Application No: EP/35/22/HH
Site Address: West House South Strand East Preston BN16 1PN
Description of works: Erection of single storey front extension, first floor front/side extension and alterations to fenestration/openings.

Thank you for your internet representation made on 17th May 2022 which has been recorded as an objection with the comments as follows:

I am writing to object to planning application EP/35/22/HH

E ELEV

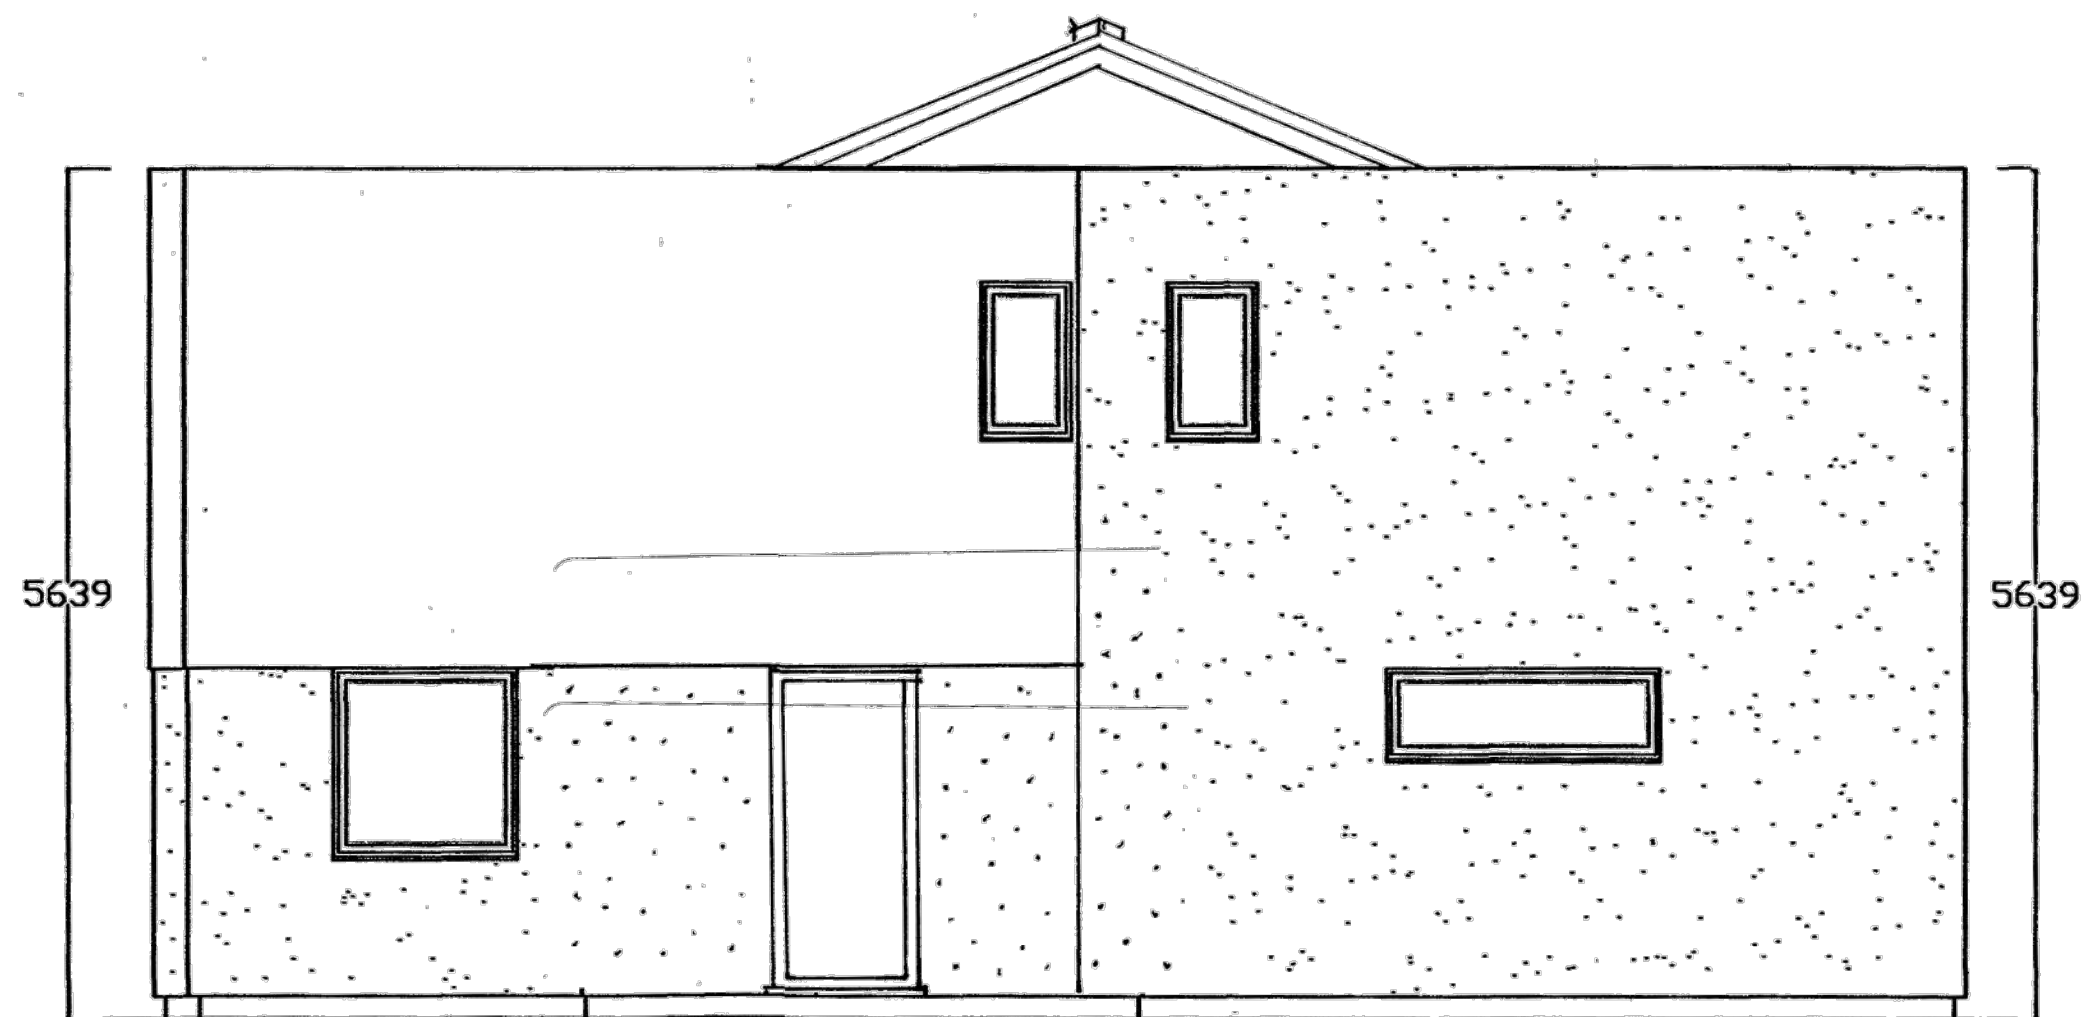
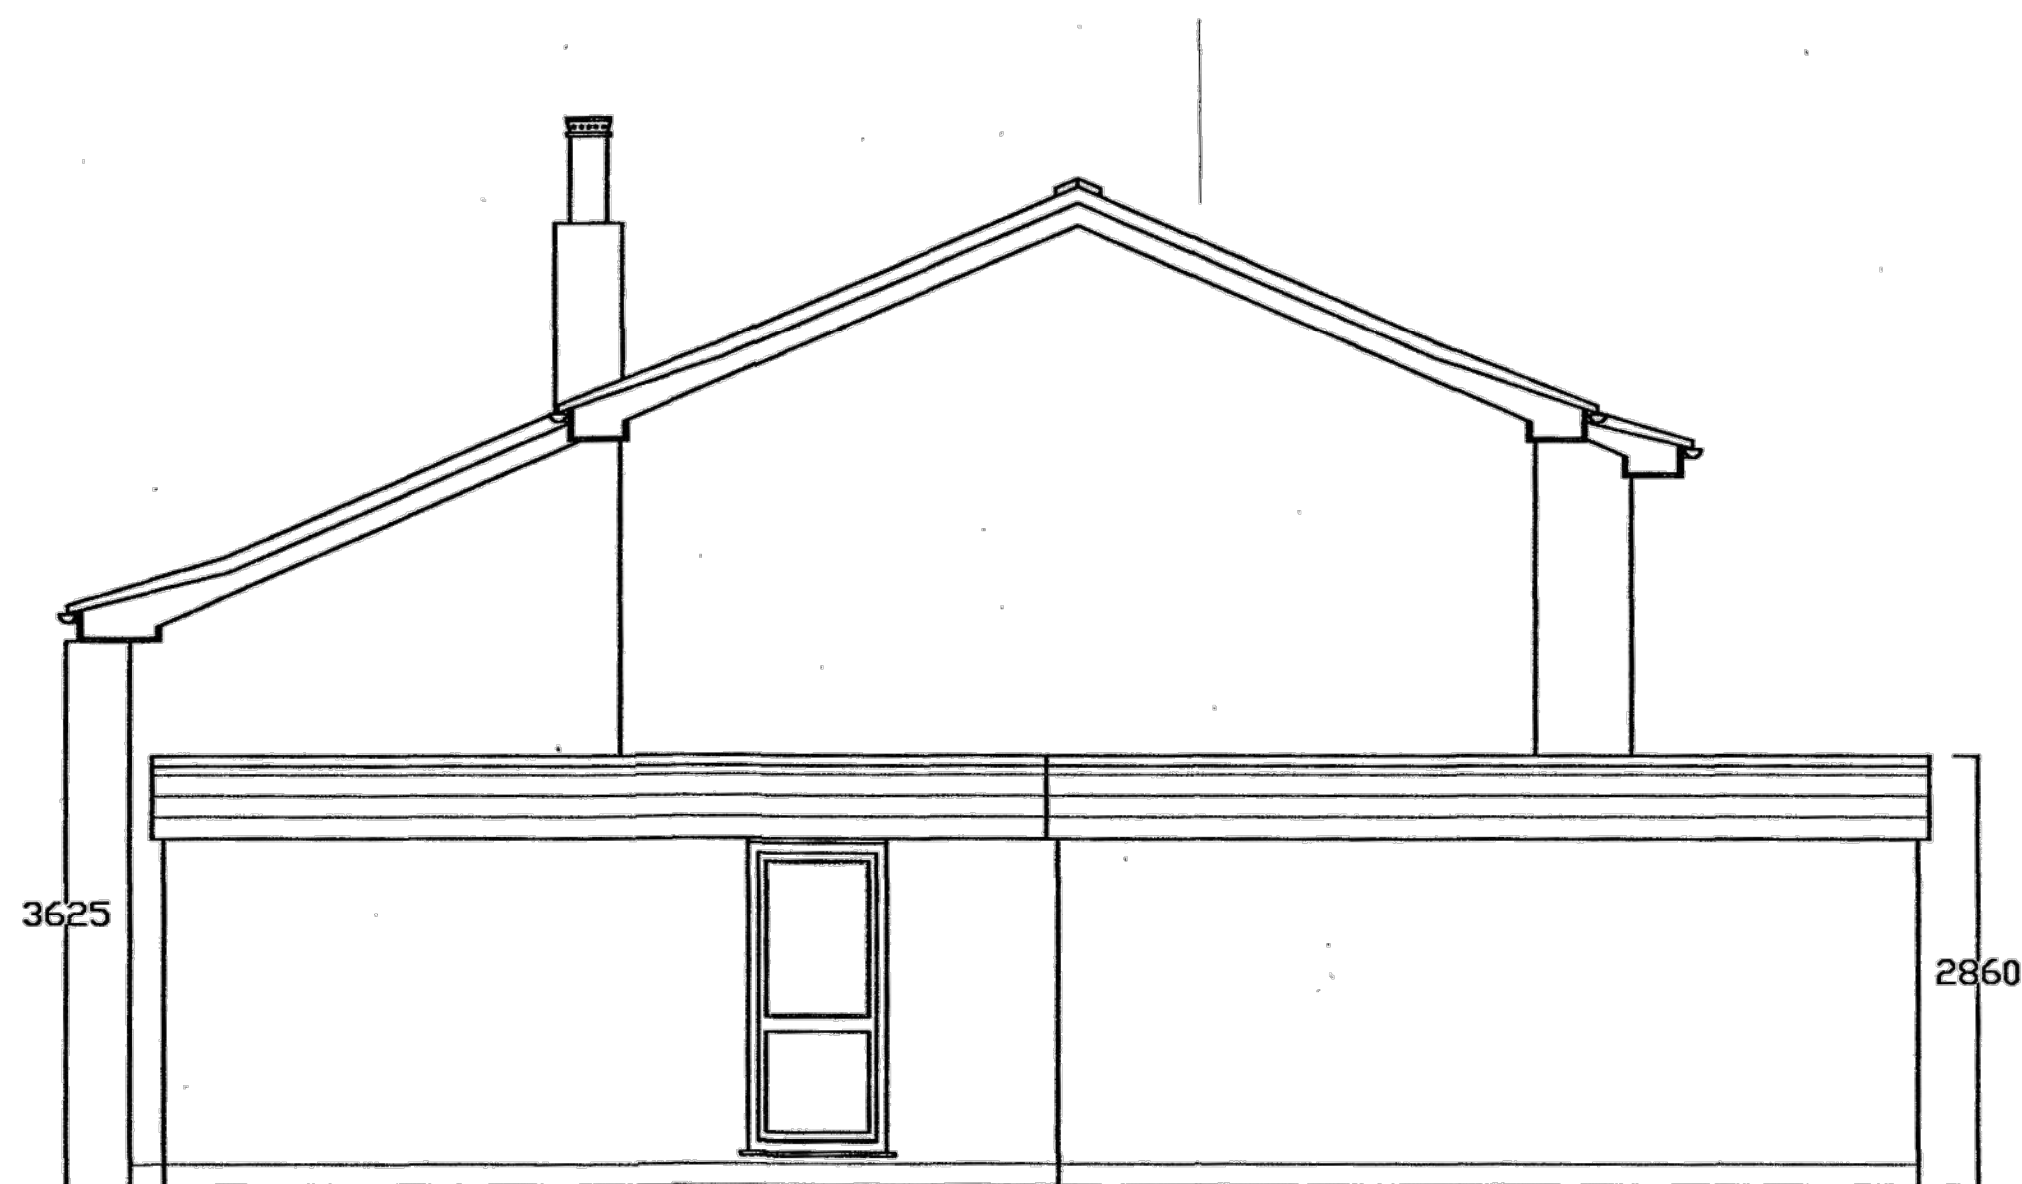
This together with the installation of a glass balcony without permission prior to this application and after the dismissal of the last application.

The wooden balcony used to obscure at least 50% of the view and now with clear glass by its nature West House have a clear view into my property, garden, driveway, garage , front habitable rooms - even when they are sitting down, together with views of my neighbours properties driveway and garages.

S ELEV

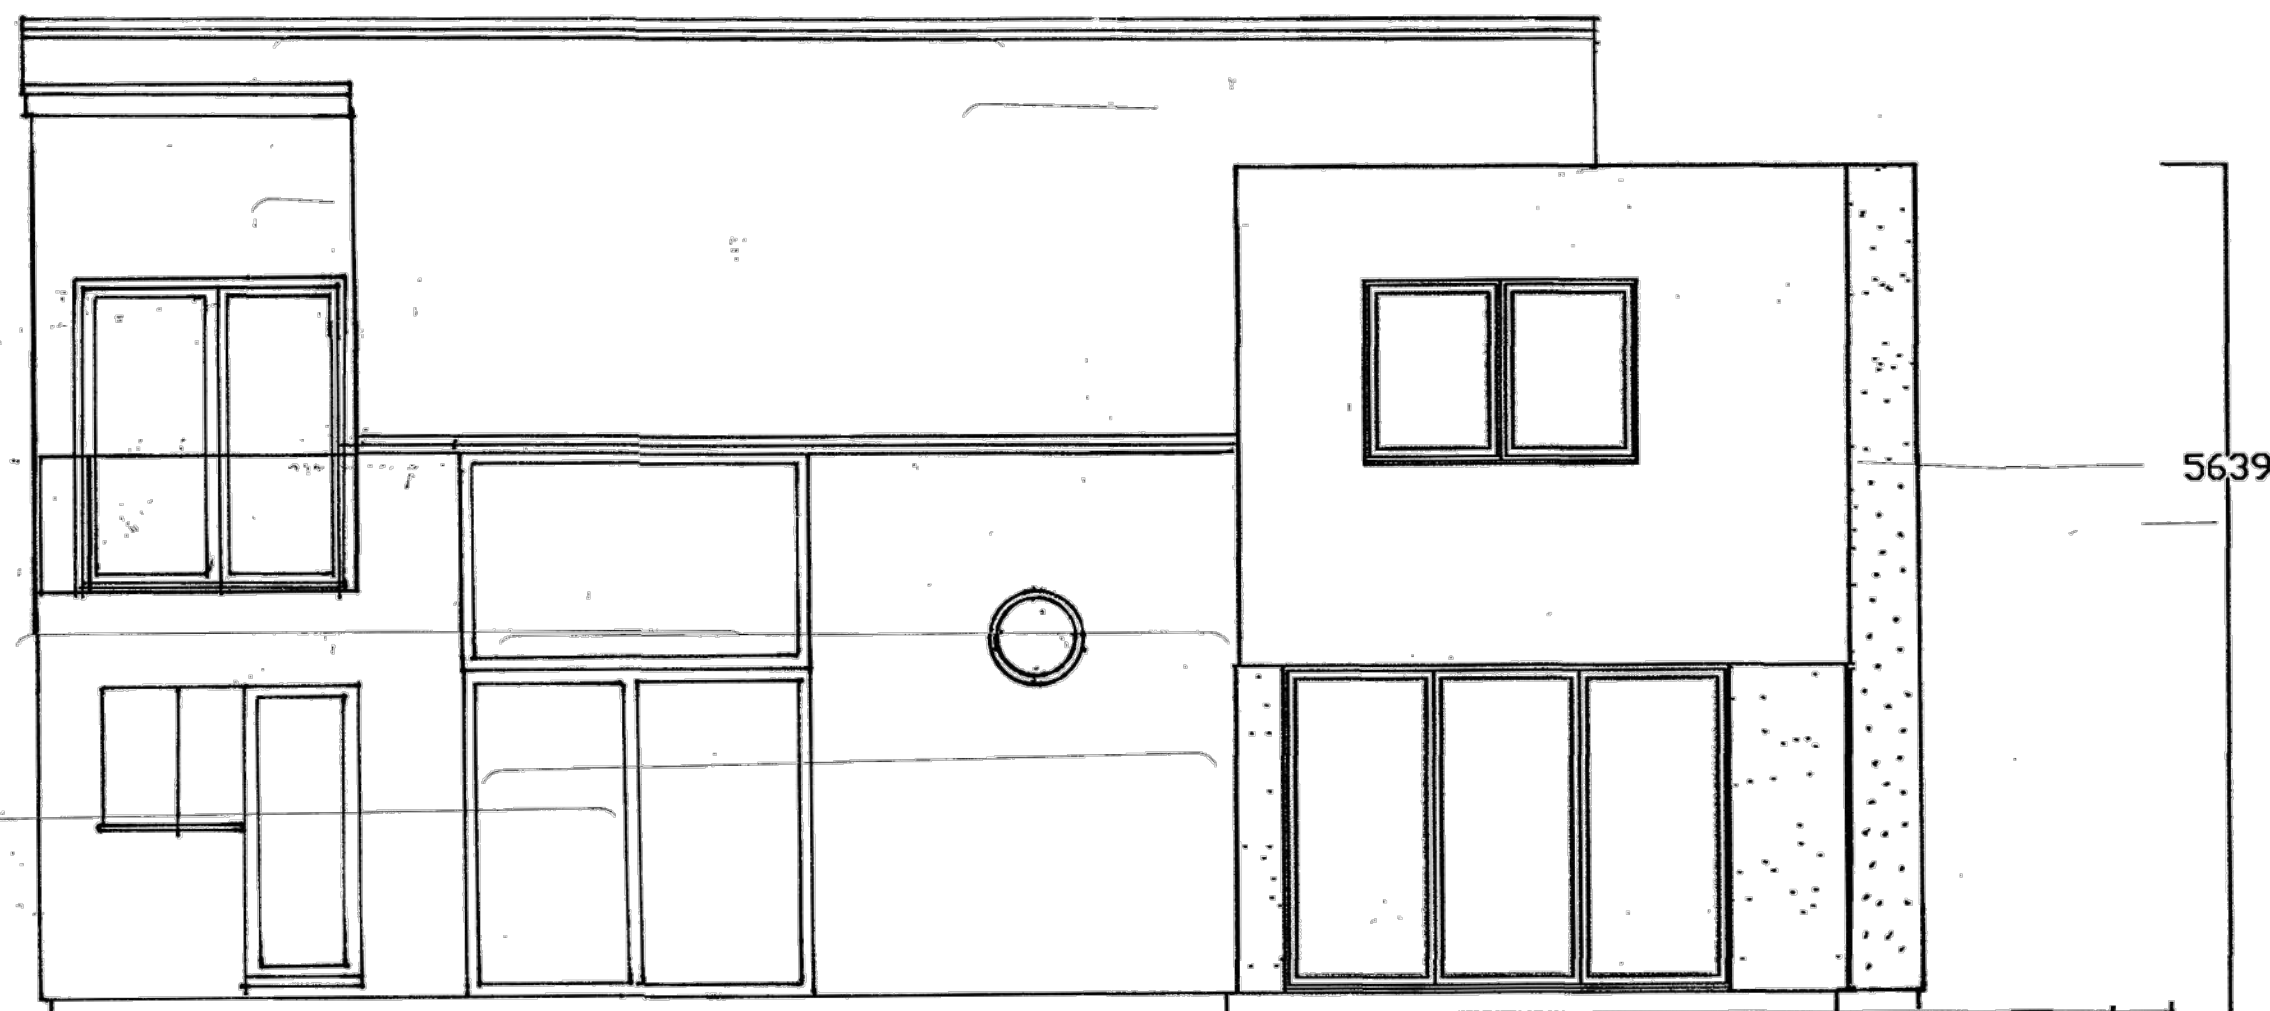
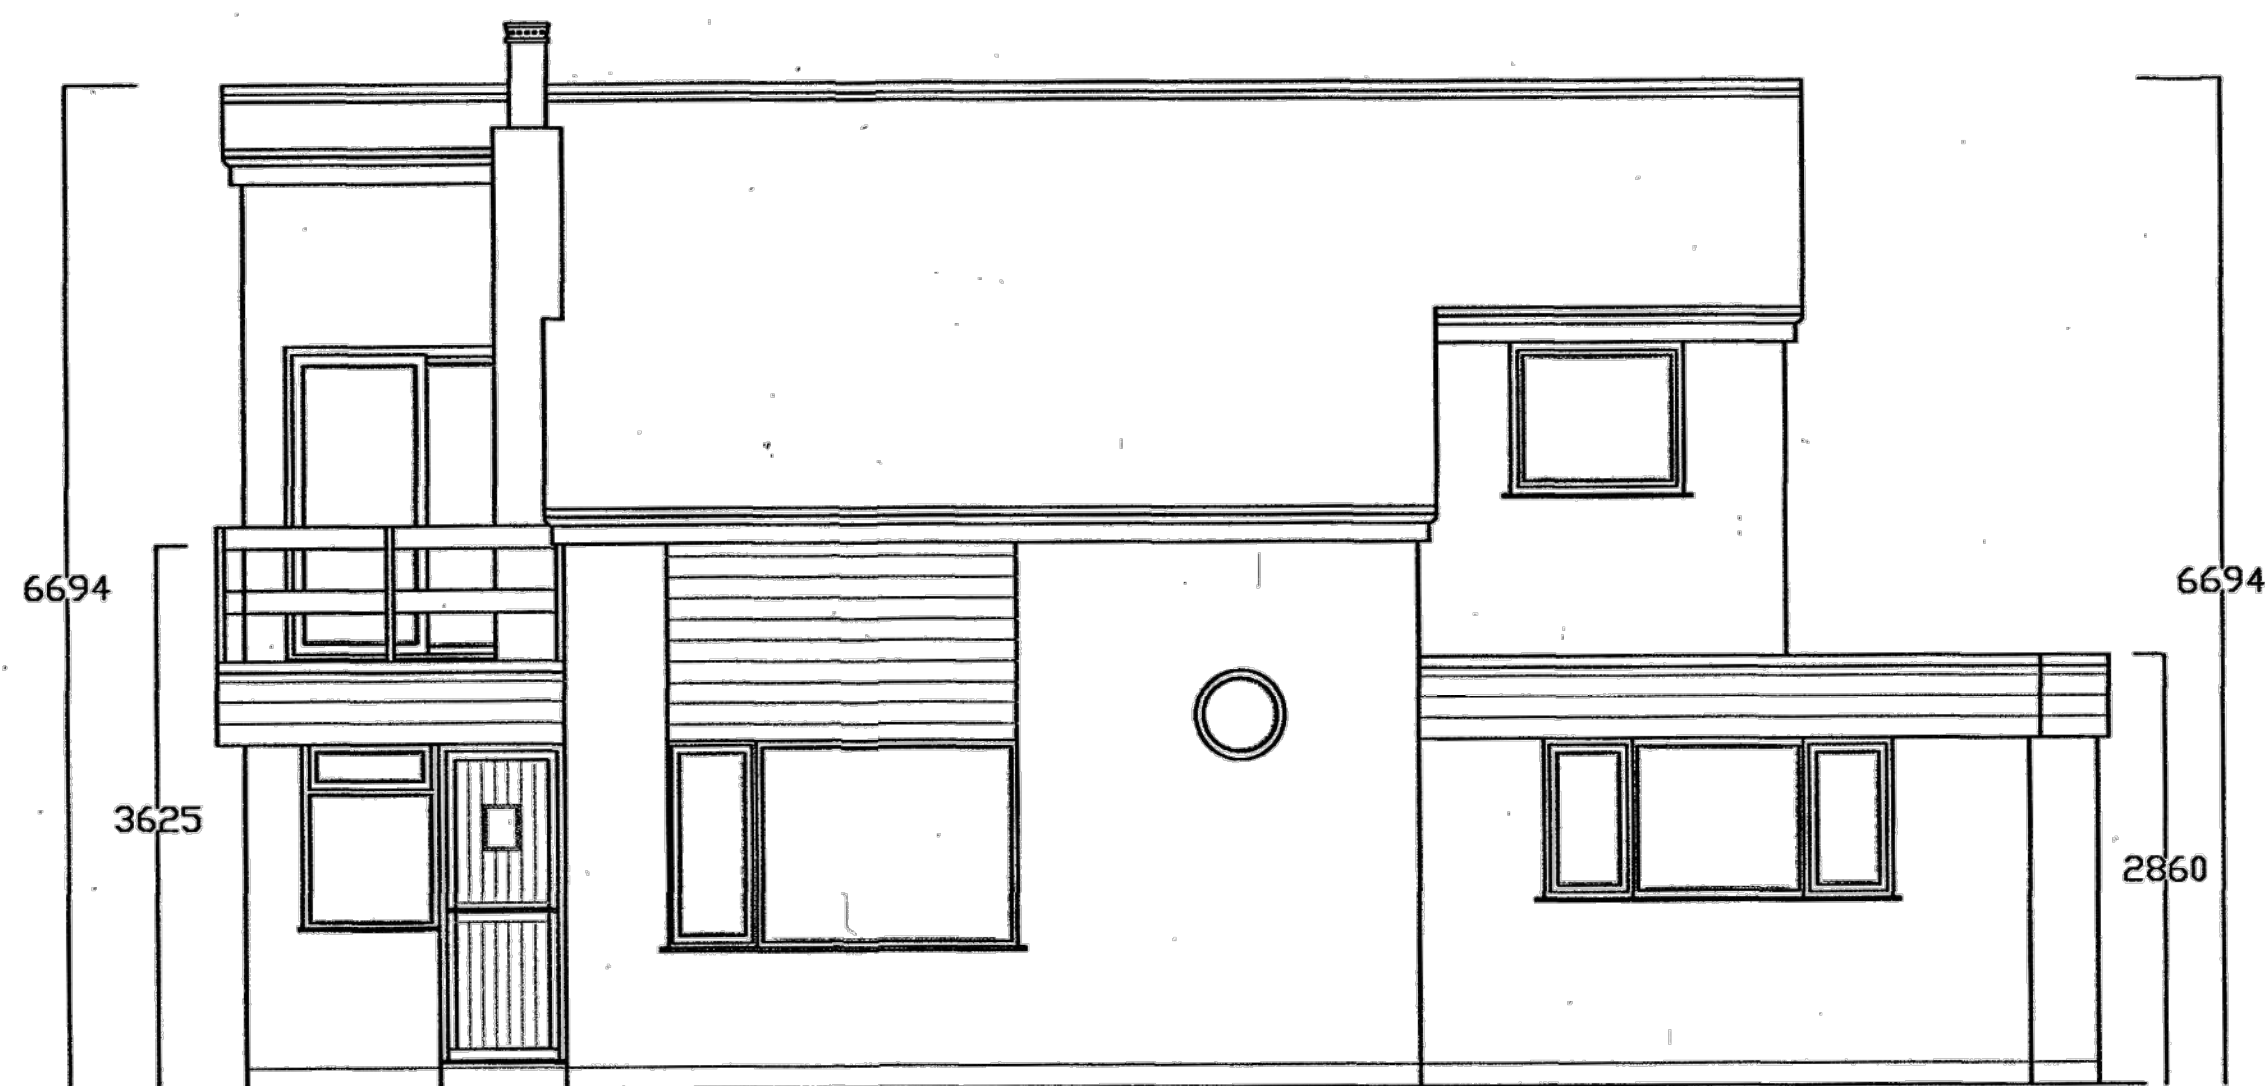
I am also concerned with the large proposed glass installation above the door at the rear of the property together with a bedroom window which again will look directly into my property.

I would respectfully ask that if this application or a revised version of it is considered that the glass is changed to 1.7 and obscured for the existing balcony. New/replacement glazing installed is opaque and fixed shut on southern elevation.
